DRB Application No.: <u>04DRB-01799 (SBP)</u>	Project # <u>1003791</u>
Project Name: <u>Meridian Business Park</u>	
Agent: <u>Claudio Vigil Architects</u>	Phone No.: <u>842-1113</u>

**DRB Comments**

**RE: Lot 5, Meridian Business Park/SPBP**

**ELEVATIONS**

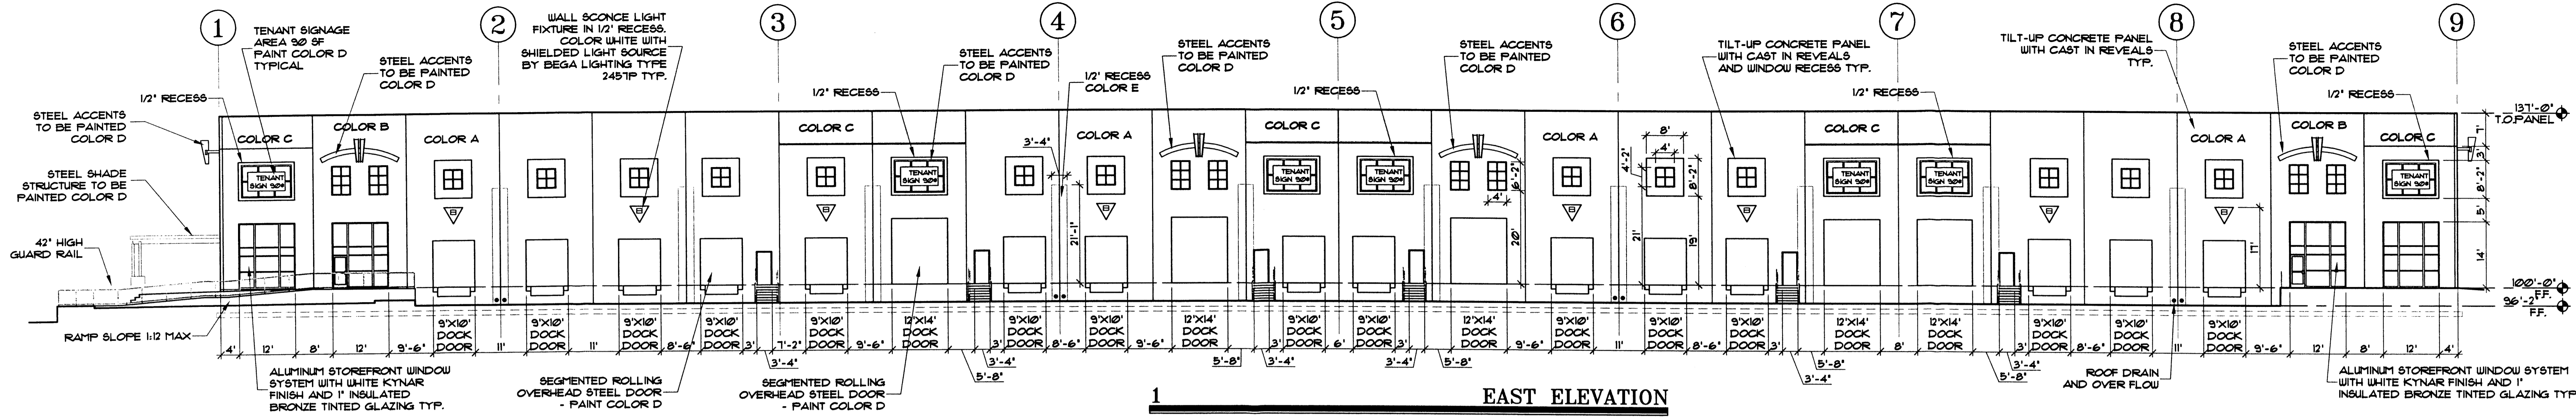
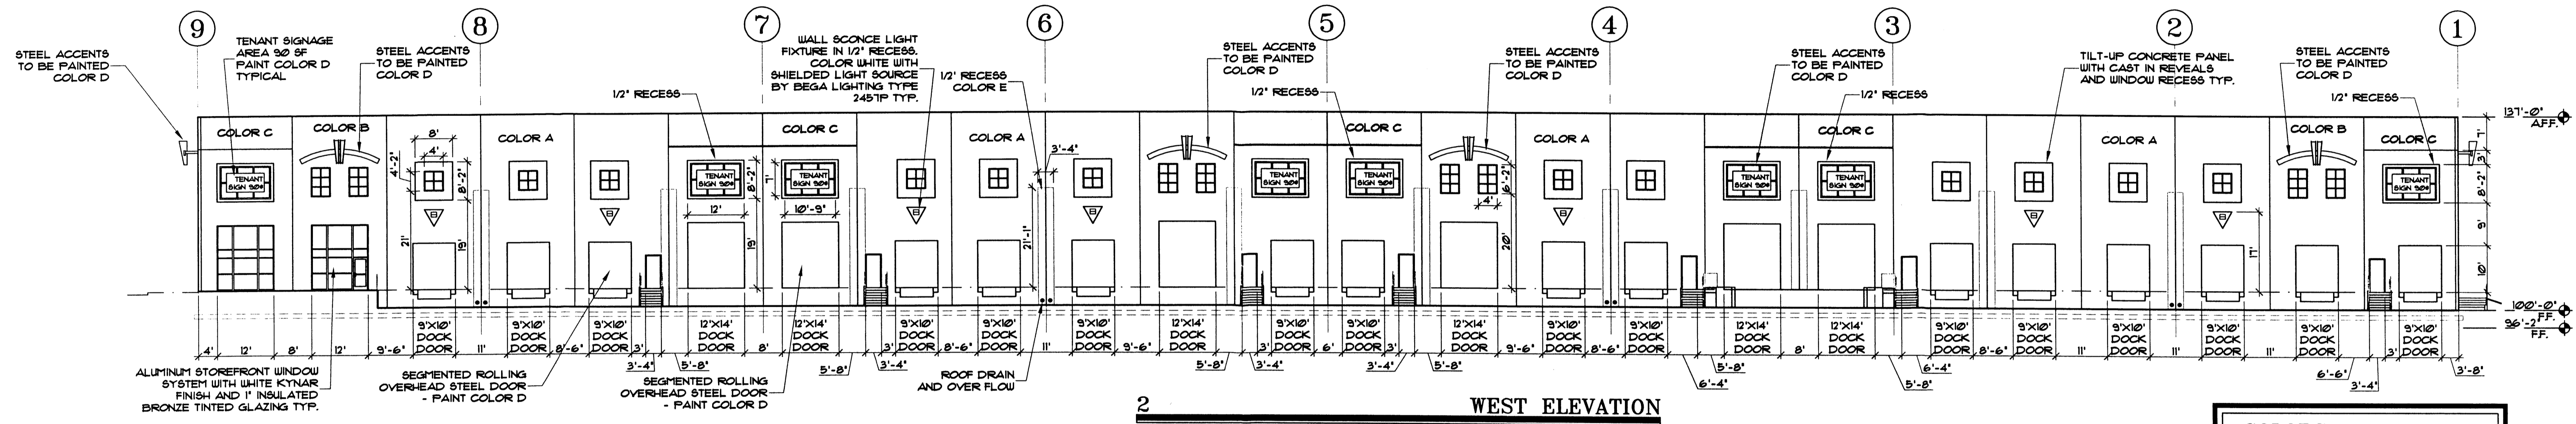
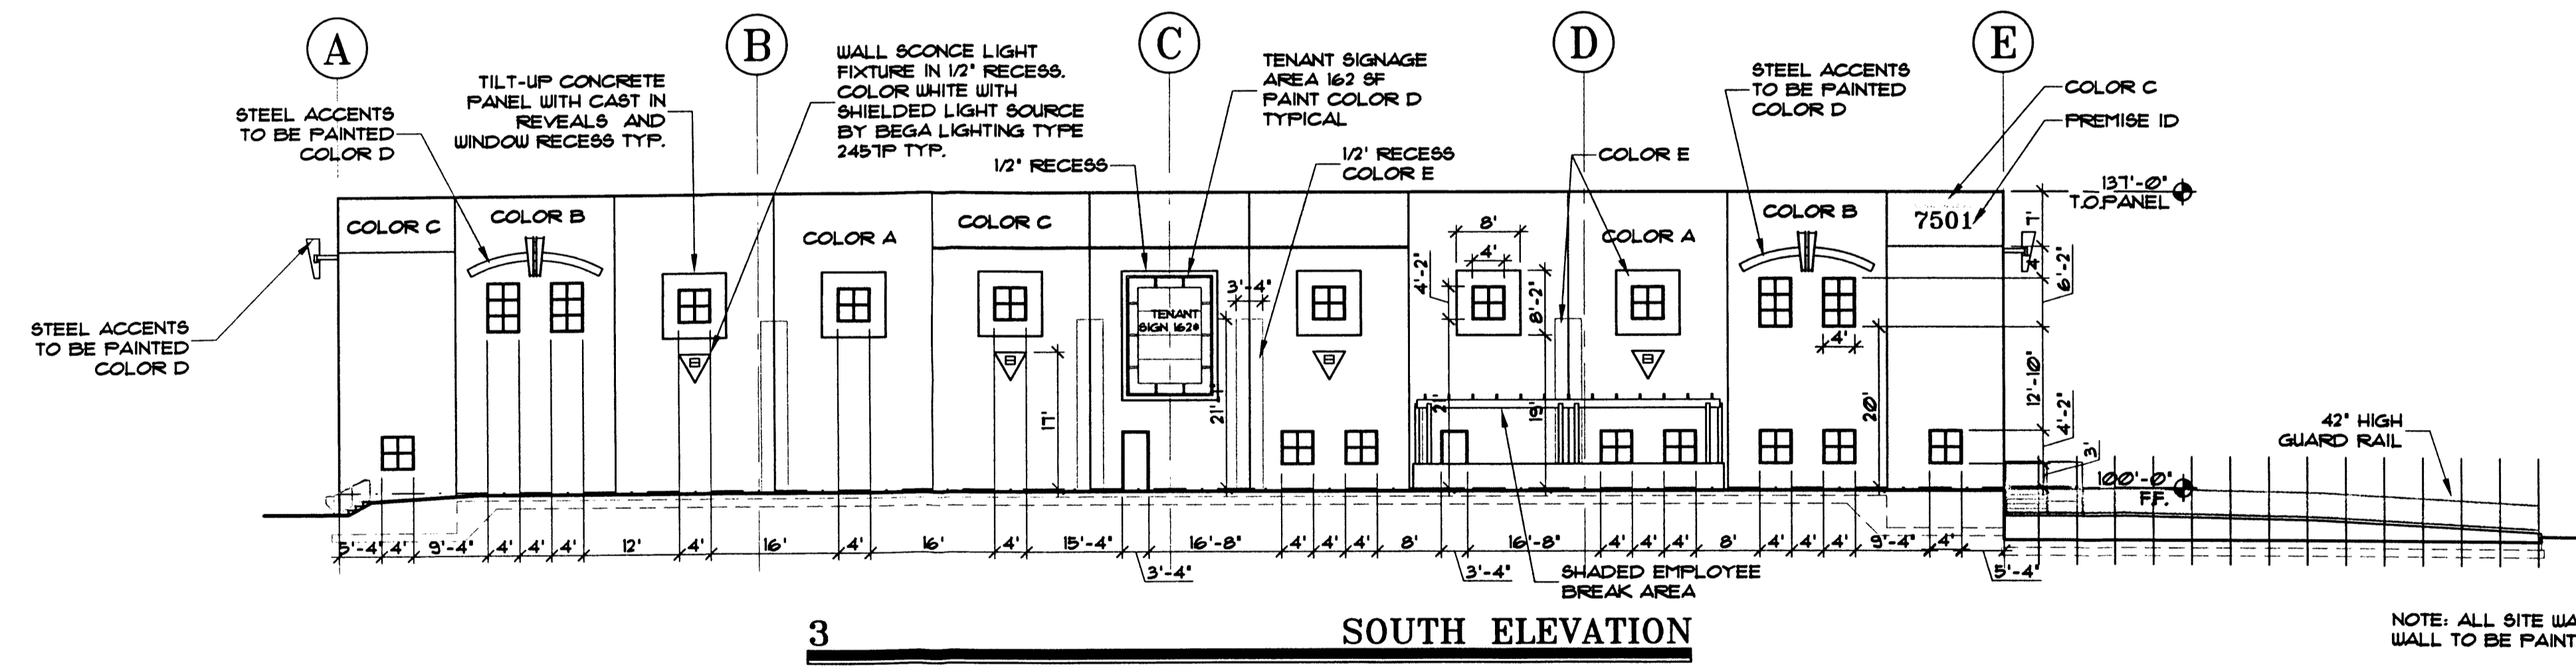
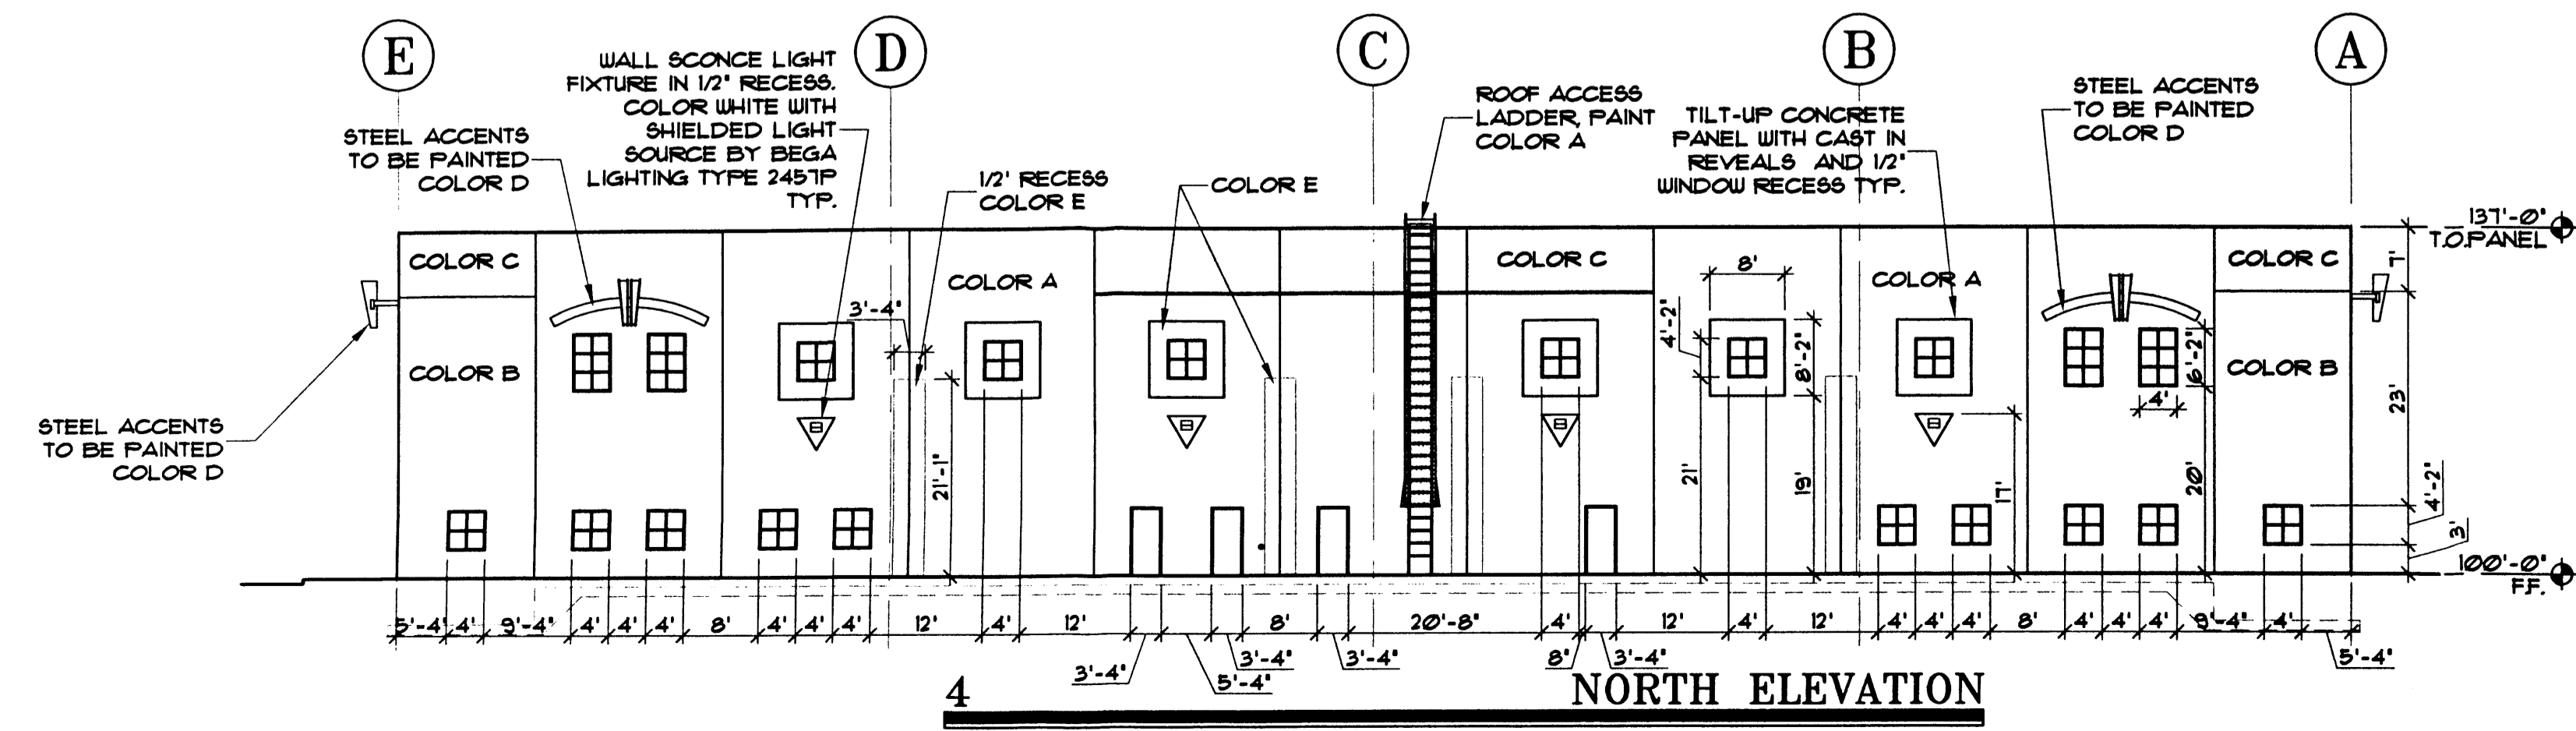
- ✓ The Master Plan requires a 70/30 percent mix of deciduous/evergreen trees per the Admin. Amend. approved in 1997. The trees listed are all deciduous.
- ✓ The Landscape Plan should have the existing & proposed easements shown per the Checklist.
- ✓ The building mounted signs should have the colors listed.

## UTILITIES PLAN

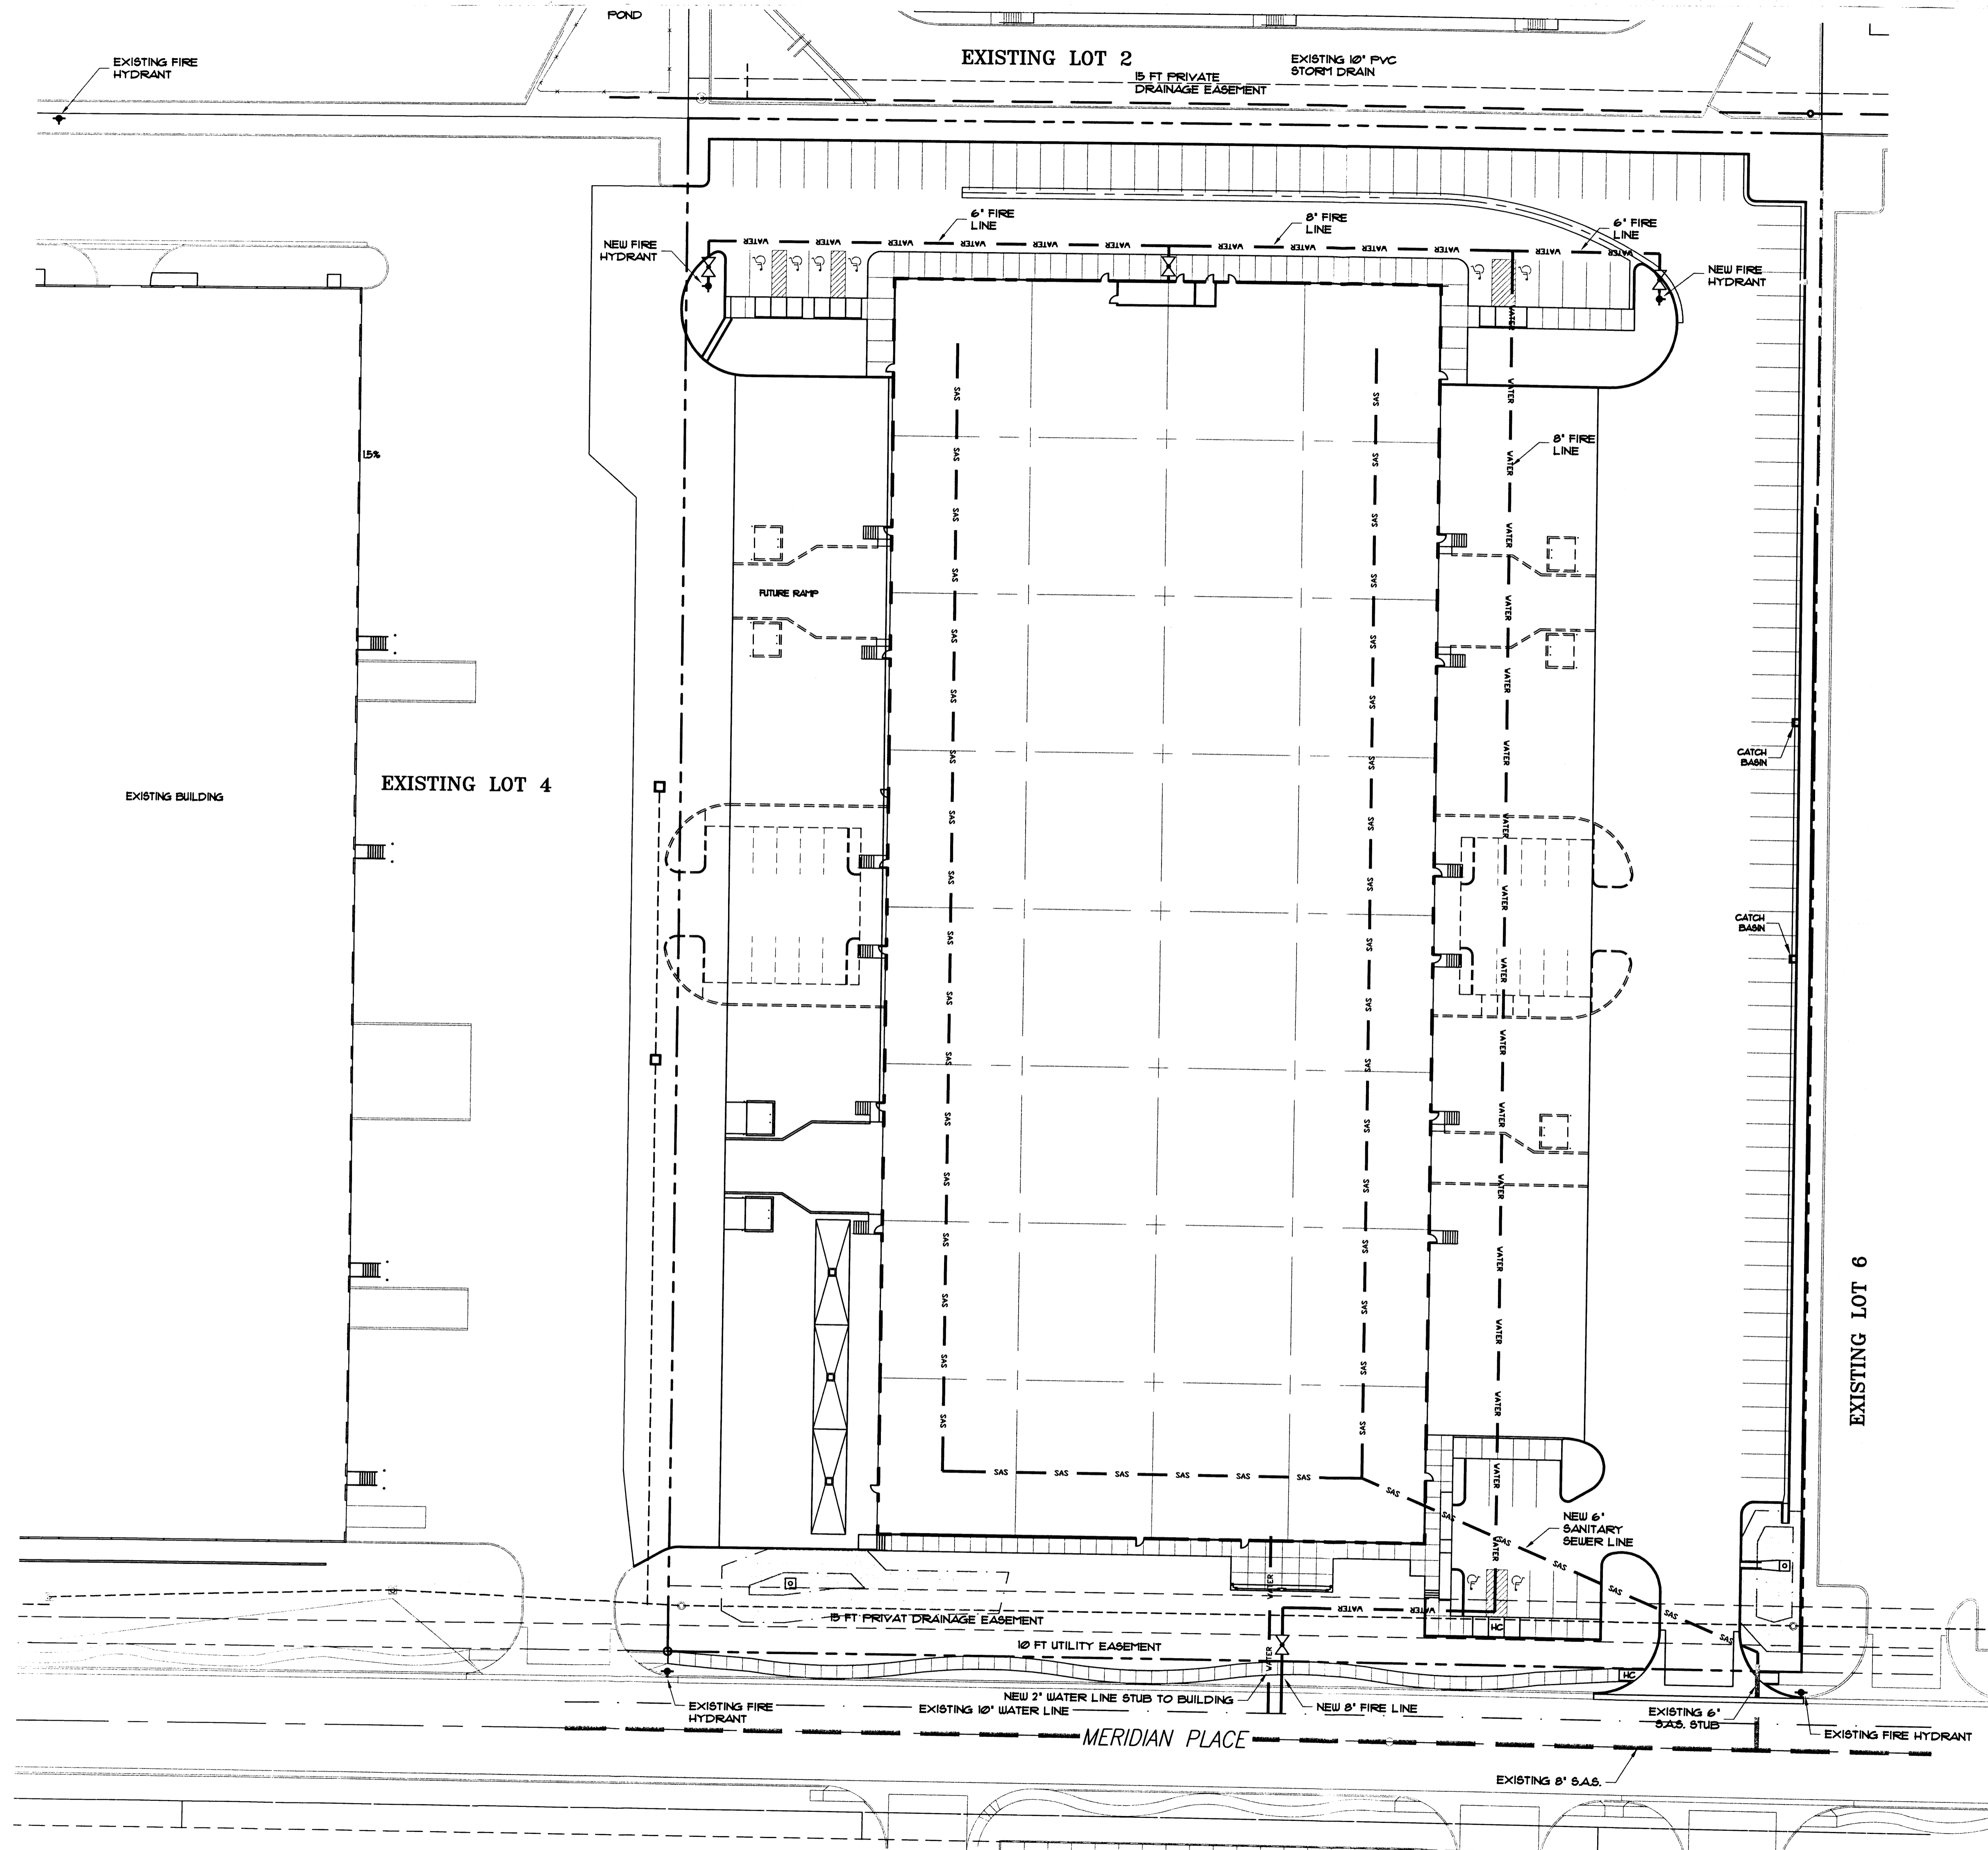
UTILITIES: Copy of Fire Flow Calculation sheet. Need to verify system capacity.
